APPENDIX D RECOMMENDED CHANGES TO CONDITIONS

- A13. Prior to the lodgement of the first Future Development Application, the Applicant shall revise the Sydney Metro Martin Place Station Precinct Consolidated Design Guidelines (dated September 2017), to the satisfaction of the Secretary, as follows:

Shadow cast by existing
and approved buildings

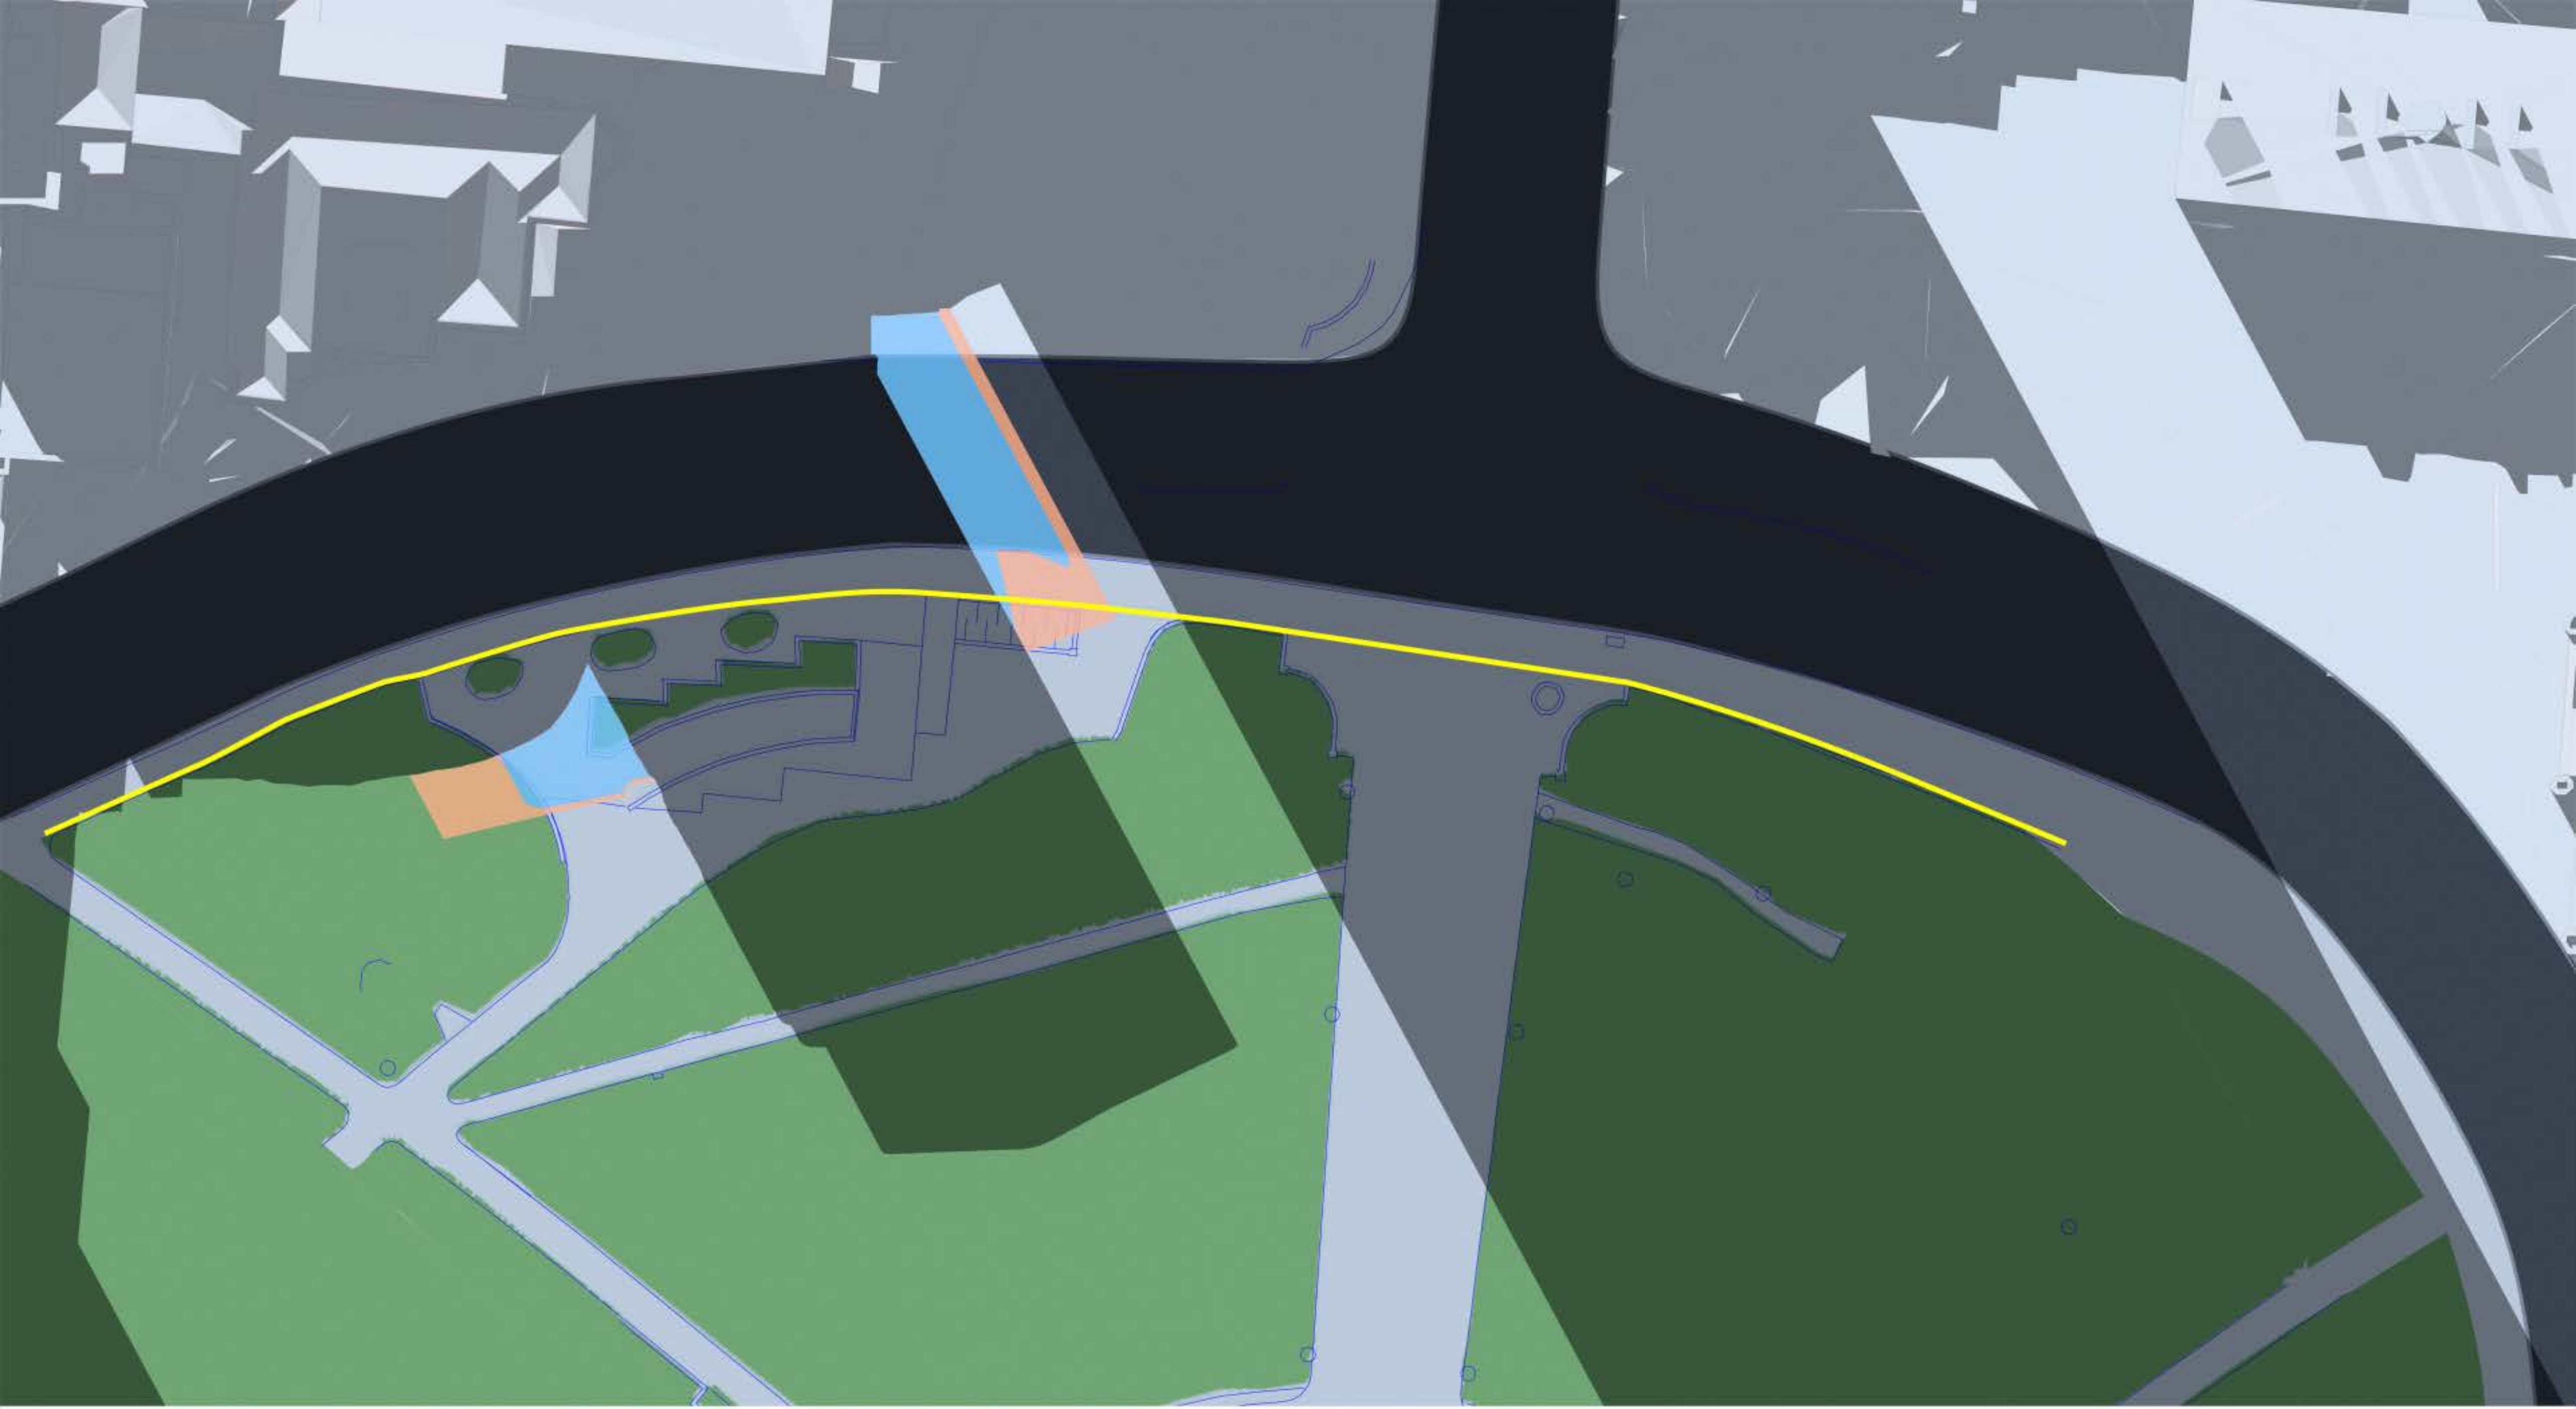
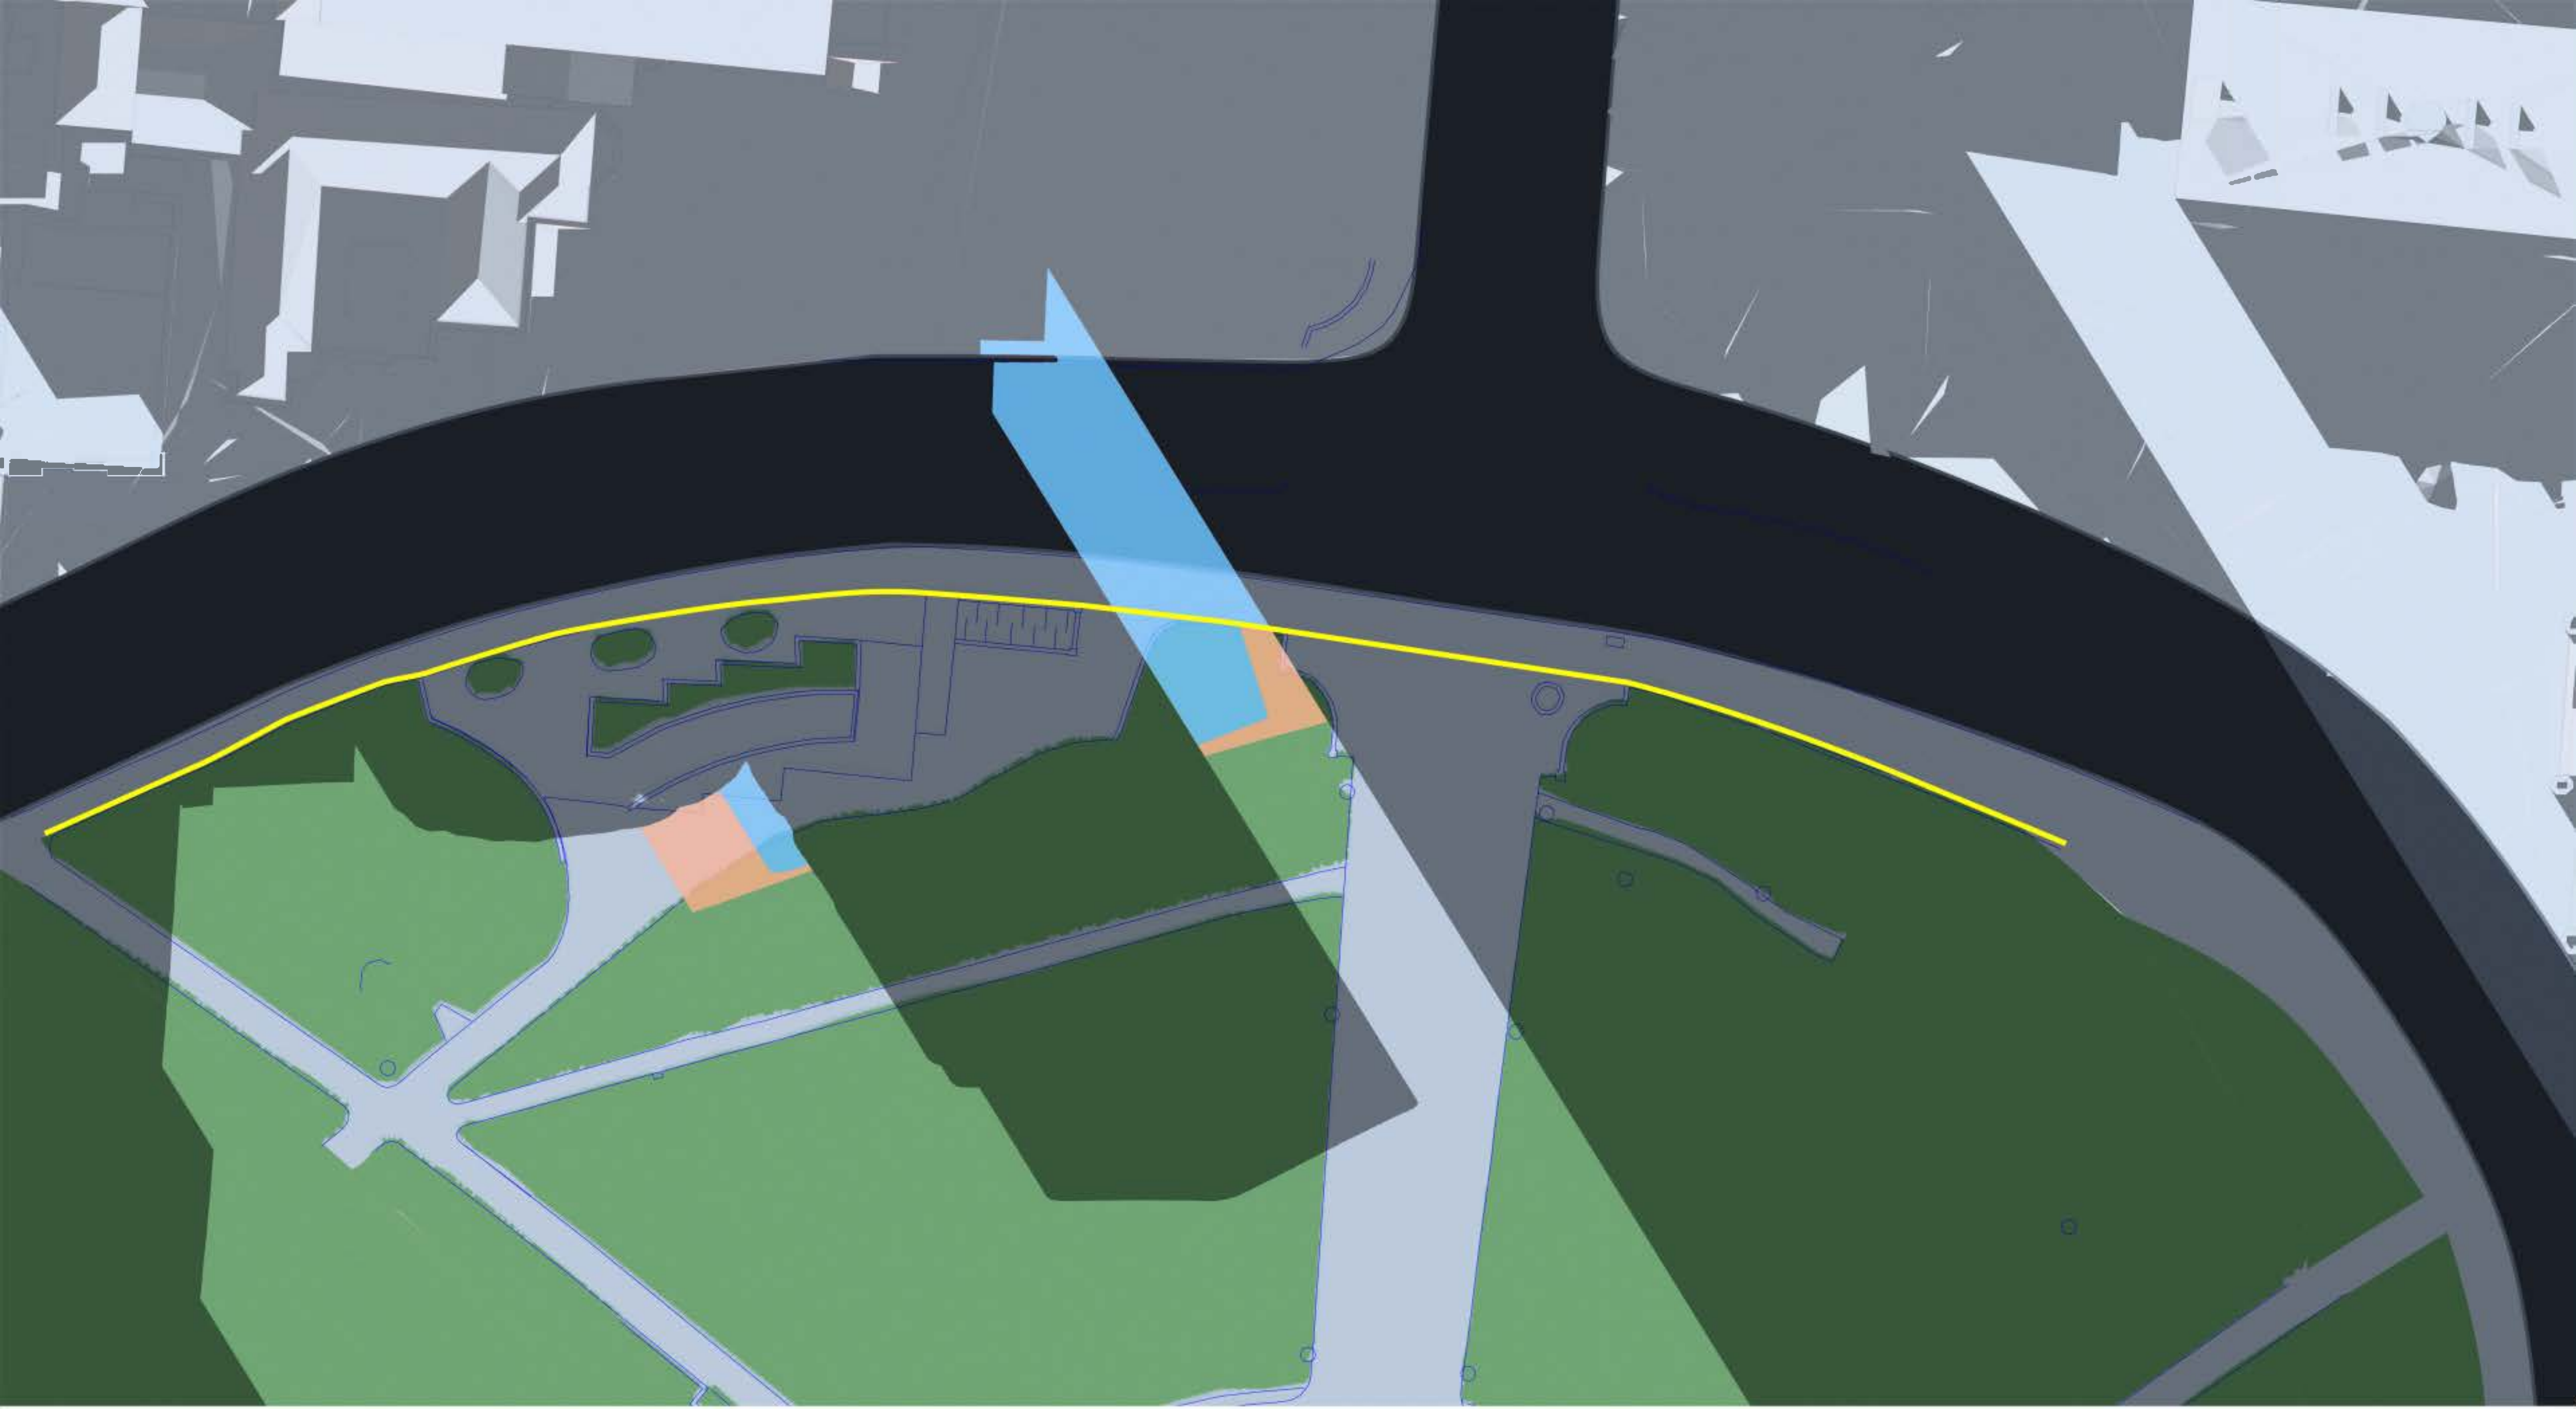
- b. In 2.2 (Public Domain): Add new **Guideline 3: Buildings on the North and South Sites shall:**
 - not result in additional overshadowing of Hyde Park between the hours of 12 and 2 pm at mid-winter (21 June), when compared to the shadow cast by existing buildings, approved buildings and the DCP/LEP compliant envelope set out in Appendix C of the Response to Submissions, titled SSDA Addendum Shadow Analysis, prepared by Grimshaw and Johnson Pilton Walker, dated August 2017

Urban design principles - tower level

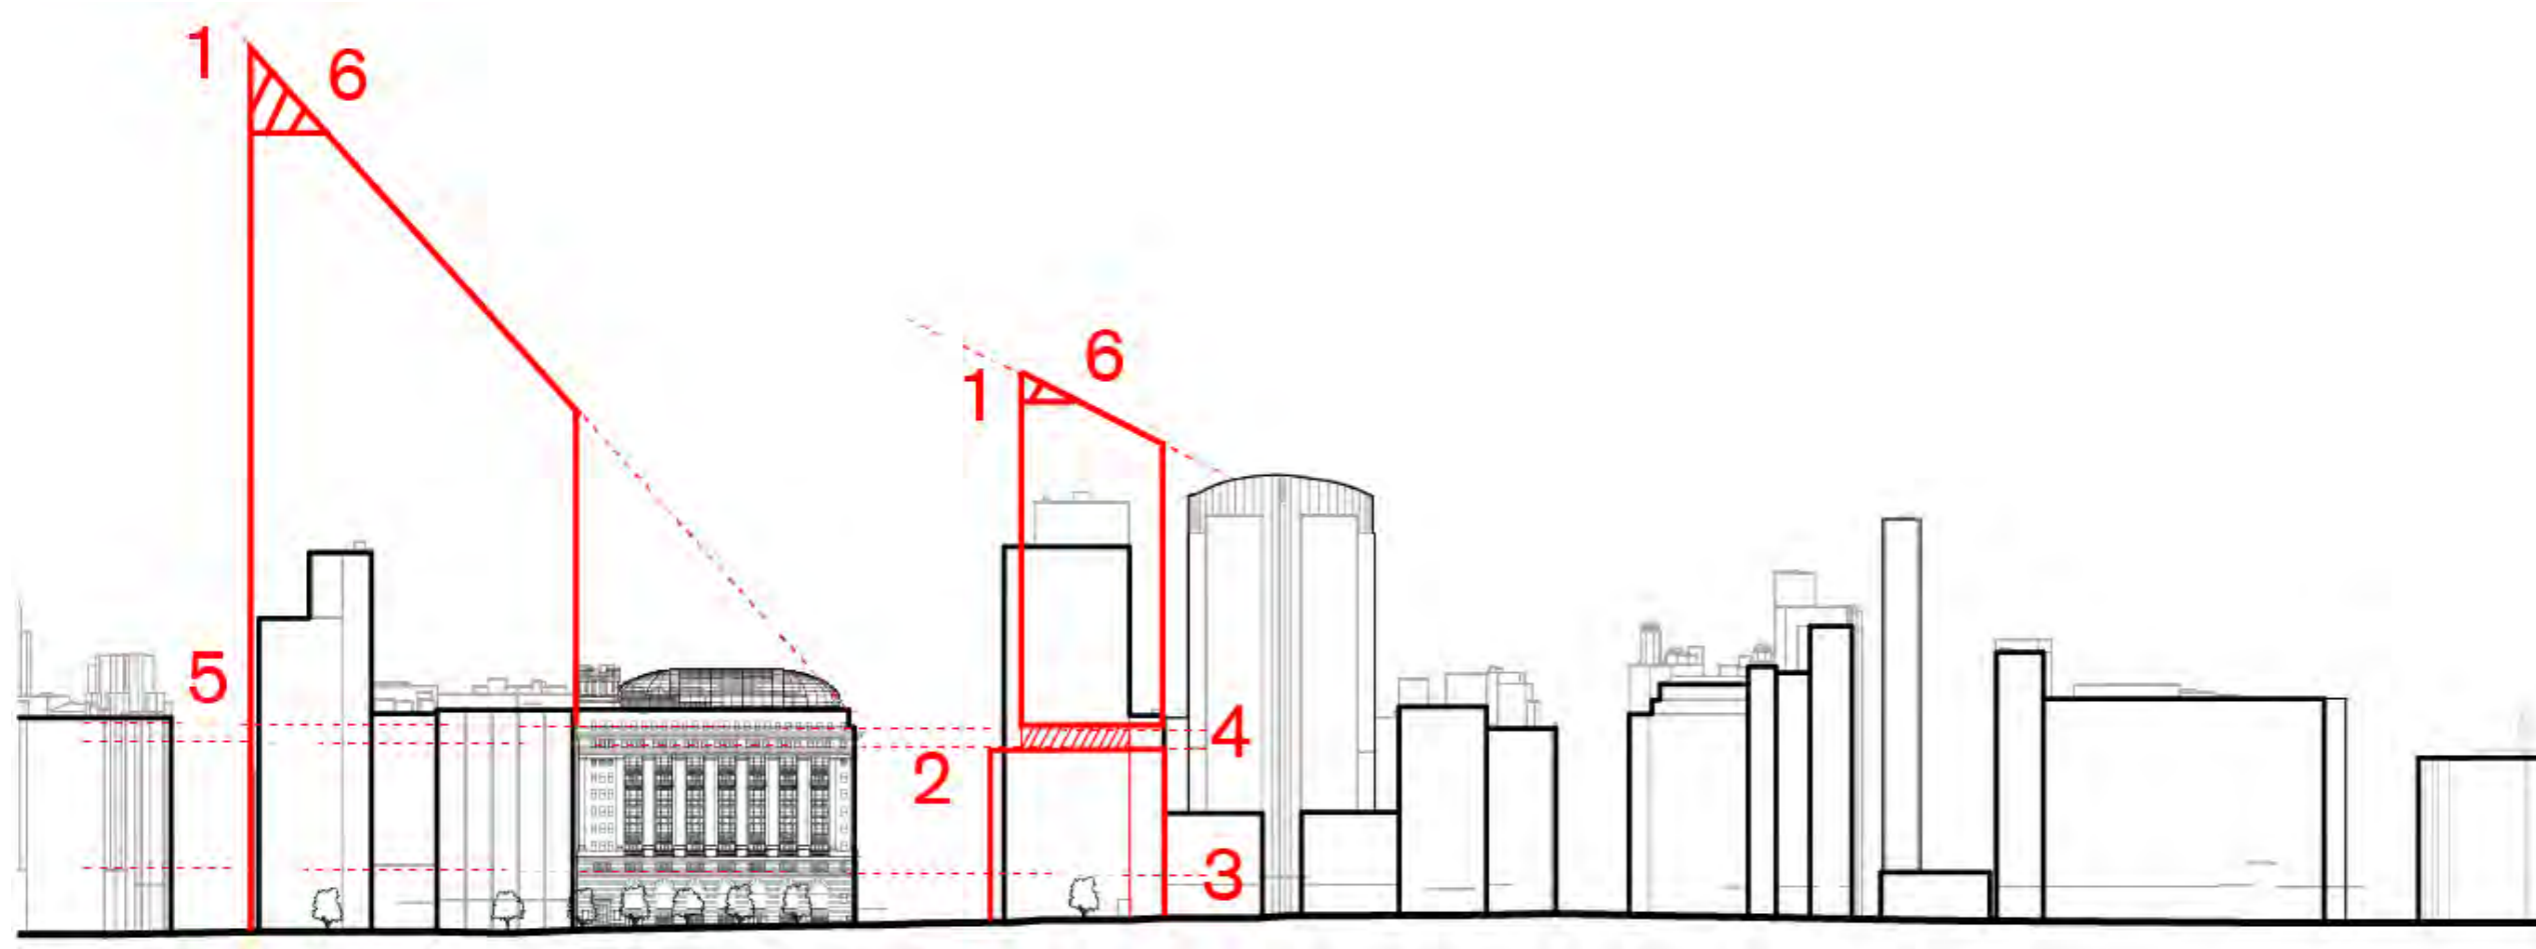
- q. In 2.4 (Graphic Representation of Development Principles): Amend diagram titled 'urban design principles – tower level' to delete points 3 and 4 (zero setback to Castlereagh and Elizabeth Streets) and renumber accordingly.
